WEST SUSSEX COUNTY COUNCIL CONSULTATION

TO:	Arun District Council FAO:Simon Davis
FROM:	WSCC - Highways Authority
DATE:	9 October 2019
LOCATION:	The Former Ship Inn Aldwick Street Aldwick PO21 3AP
SUBJECT:	AW/237/19/PL Application for variation of conditions imposed on planning reference AW/211/14/PL relating to condition 8 - delivery times & Condition 10 - delivery of goods serving the store in accordance to the Delivery Management Schedule. More information.
DATE OF SITE VISIT:	
RECOMMENDATION:	No Objection
S106 CONTRIBUTION TOTAL:	n/a / £ See below for breakdown.

Tracking Plan : Option 1
scale 1:500 @ A1

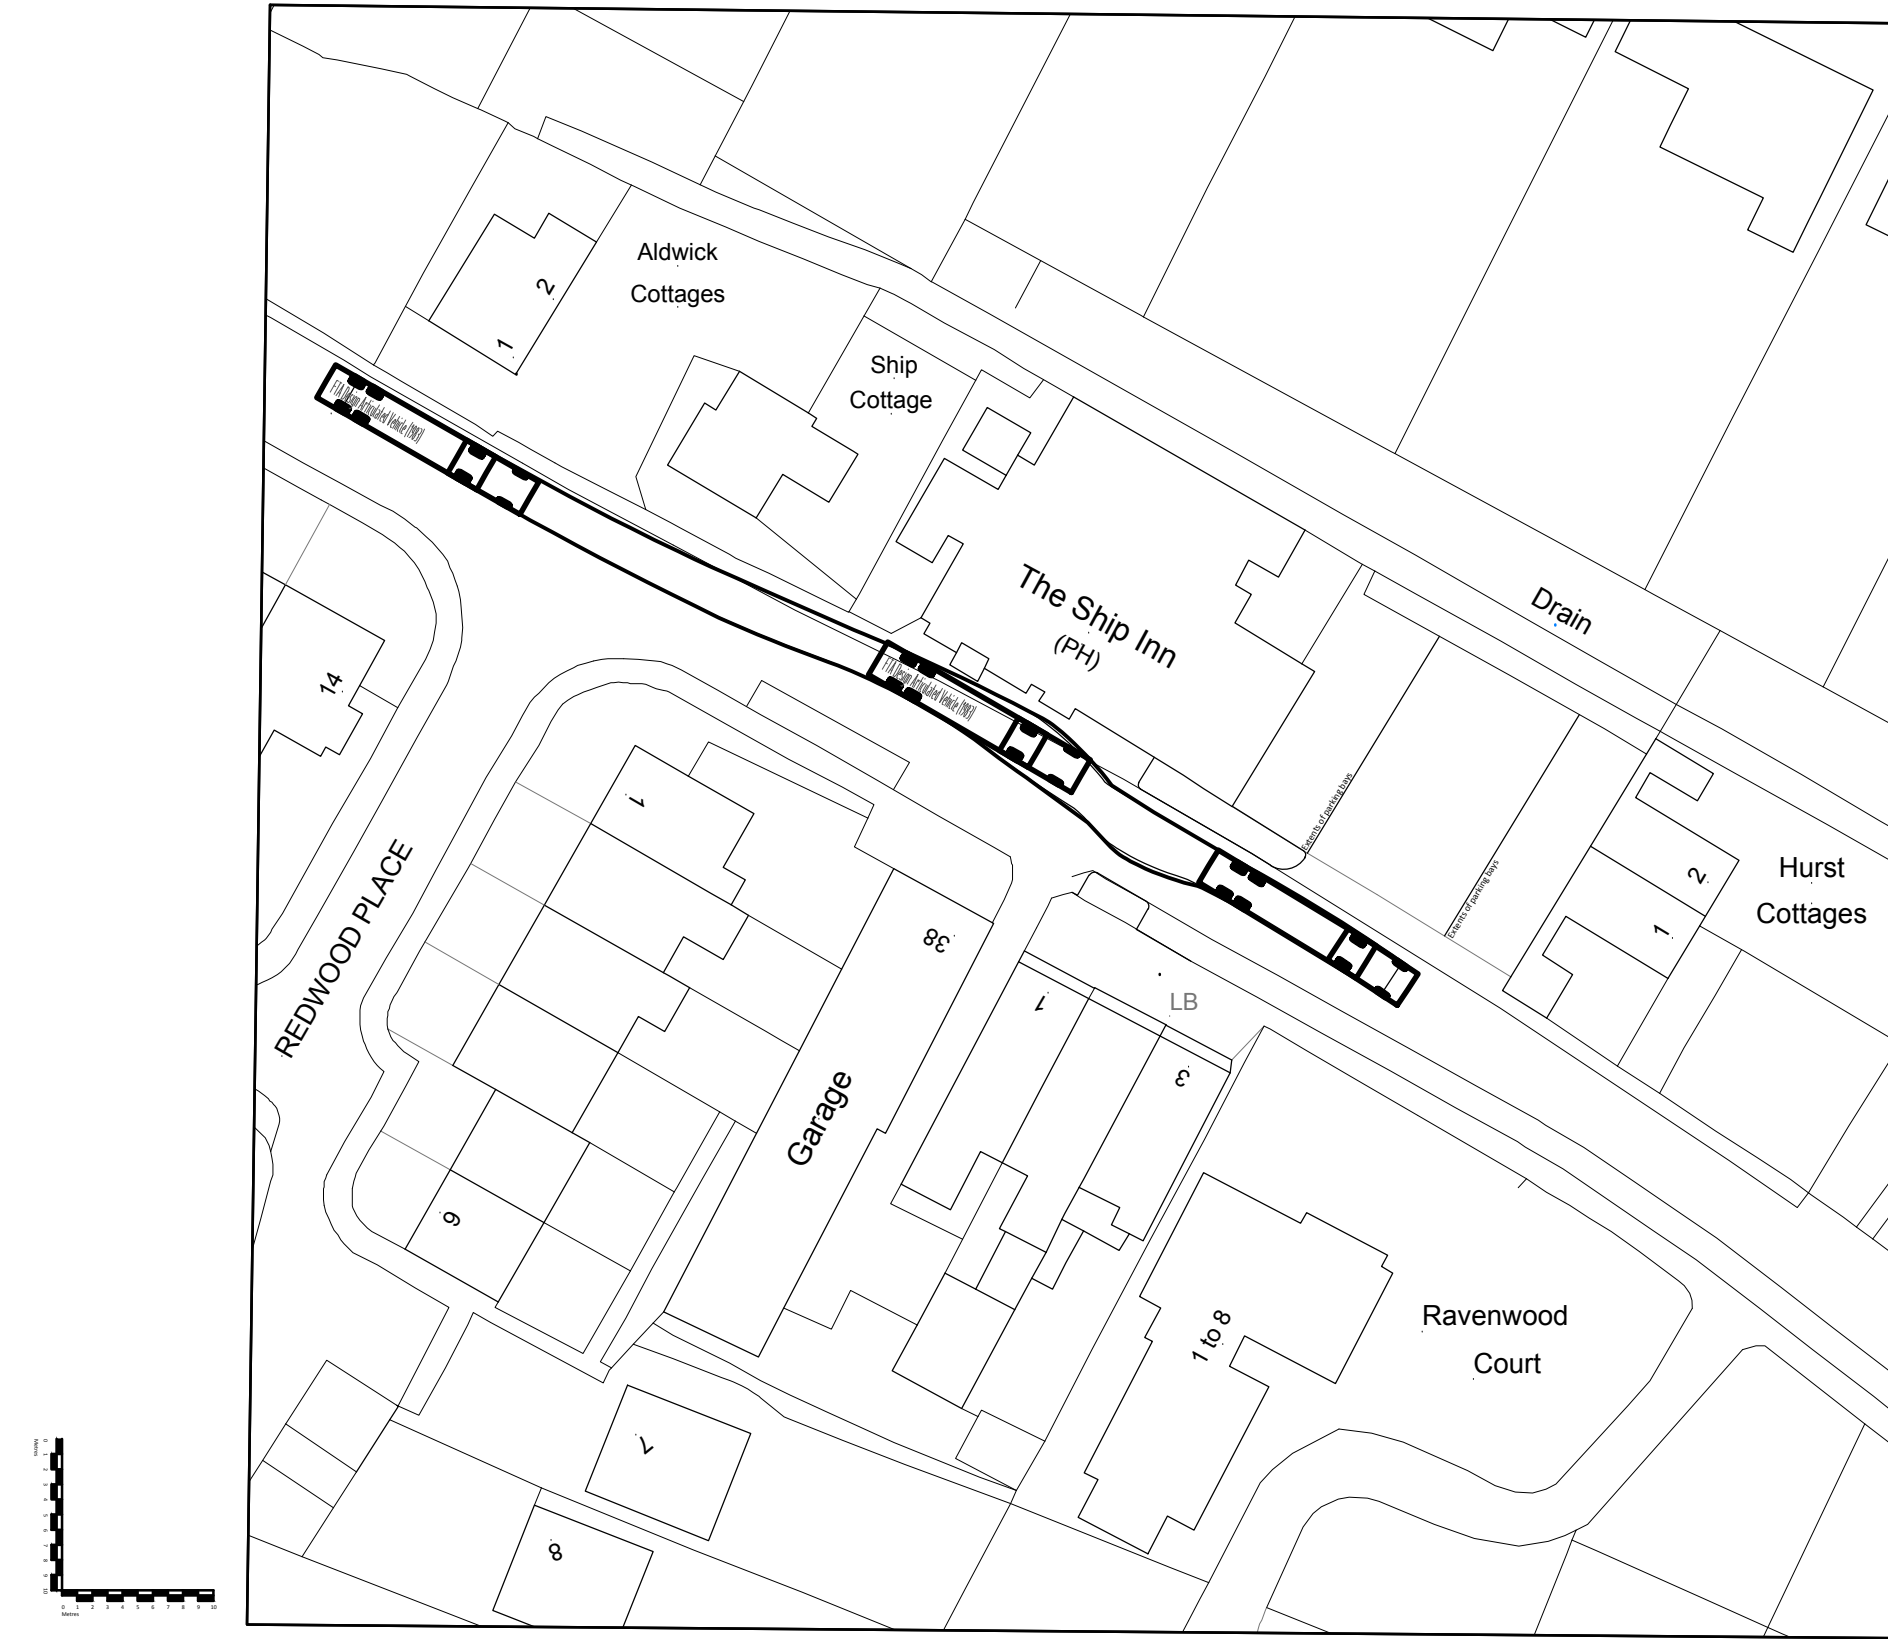
In all instances should a delivery get caught in traffic and arrive or depart when it would not be practical to use the car park; the applicant has shown that a vehicle can wait within the highway, albeit a tight manoeuvre, and the swept paths provided in drawing (B 104) evidence that two cars can pass each other when the HGV is stationed in this position.
